Subject: PF-18-00001 – Kittitas County Public Works
SR 903 & NO 5 Mine Rd. milepost 3.59 right

Re: PF-18-00001

RE: Kittitas County Upper County Shop Relocation – SEPA Comments

KITTITAS COUNTY
UPPER MAINTENANCE SHOP
SITE LAYOUT - CONCEPT D

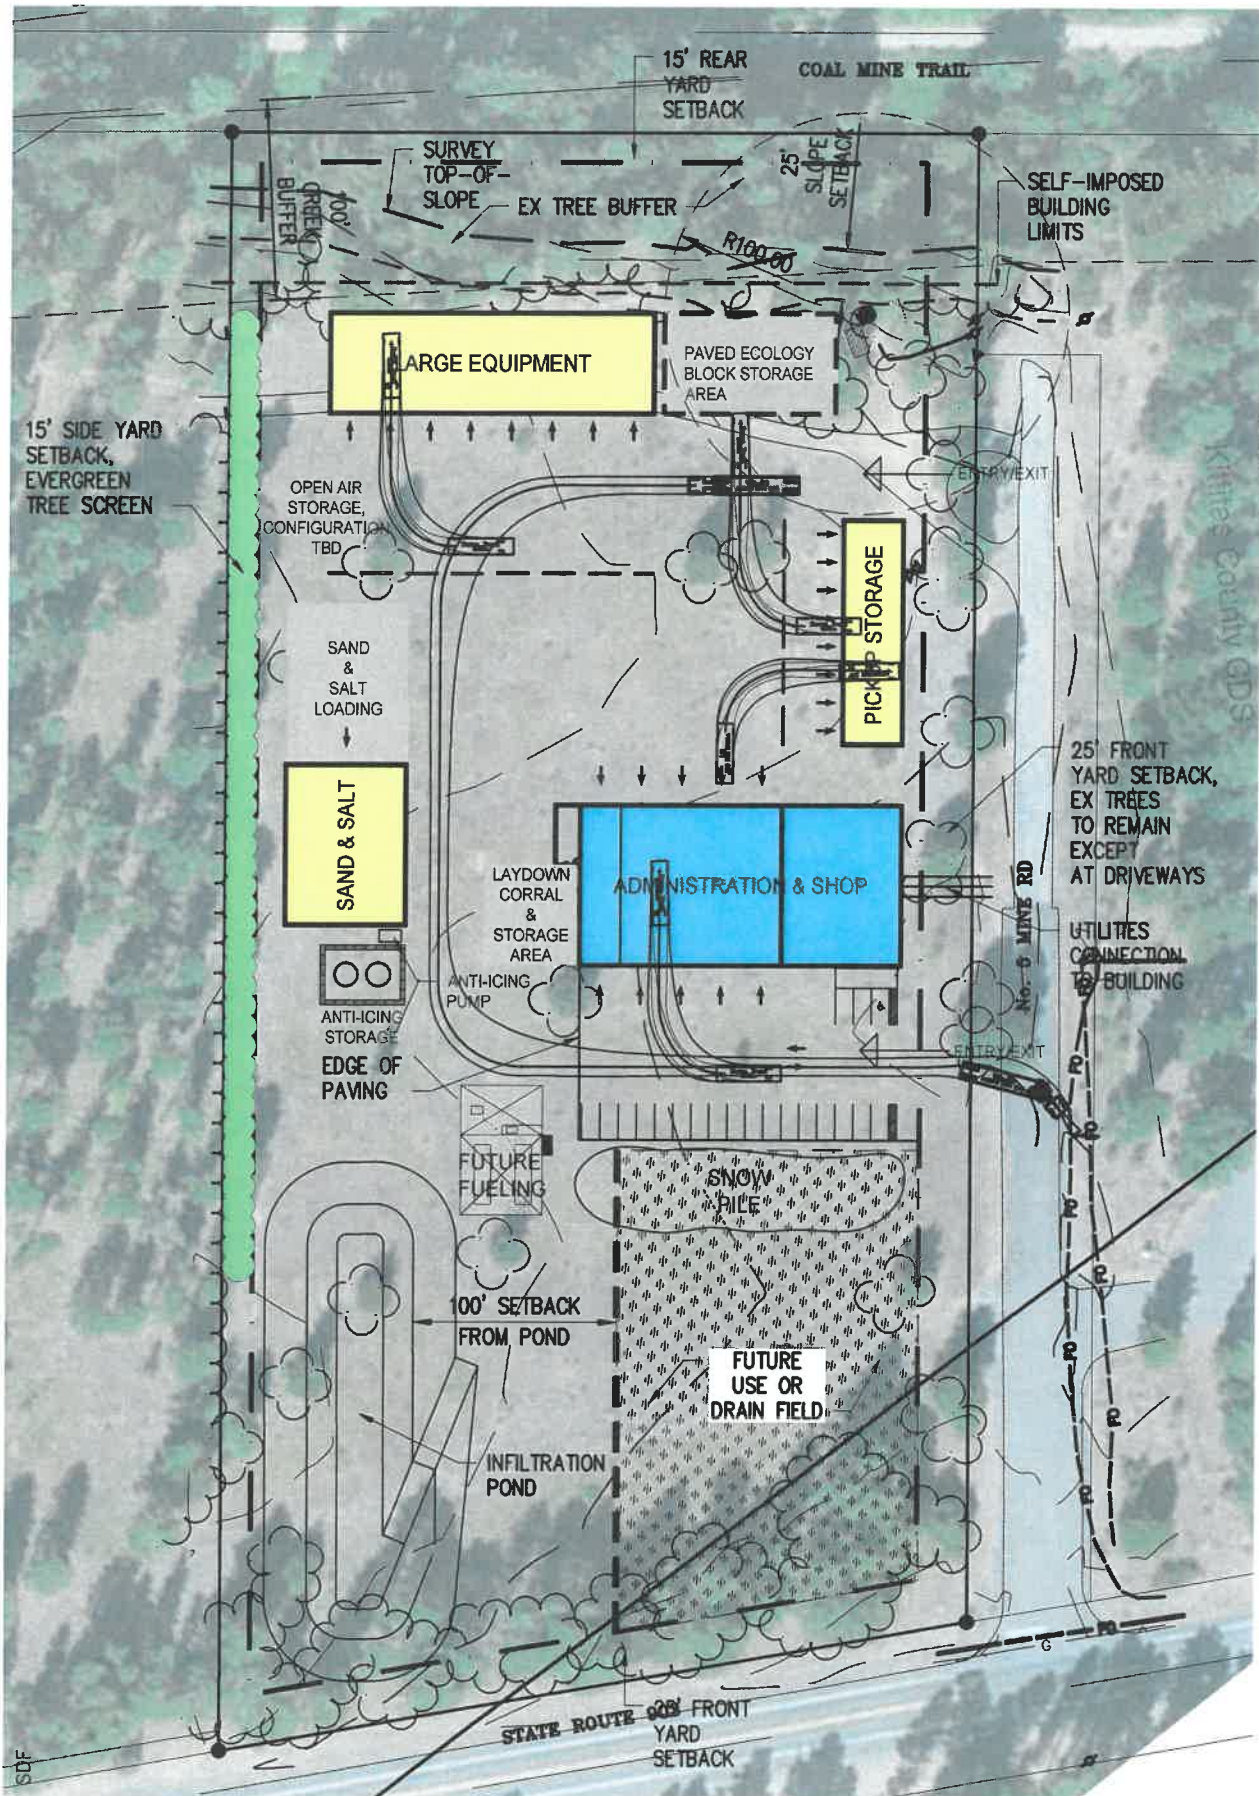
- **d. & h. Will the proposal require any new or improvements to existing roads, streets...**
 - Due to queuing during peak customer hours at the adjacent Transfer Station, vehicles back up onto SR 903 from the Transfer Station gate. This has the potential to block traffic into/out of the proposed County Shop facility.

- This proposal should include widening the SR 903 shoulder south of the Transfer Station and widening No. 5 Mine Road for the same purpose.
- **f.** peak traffic times are slightly different than listed in this response. Peak travel time on SR 903 near the proposed County Shop are:
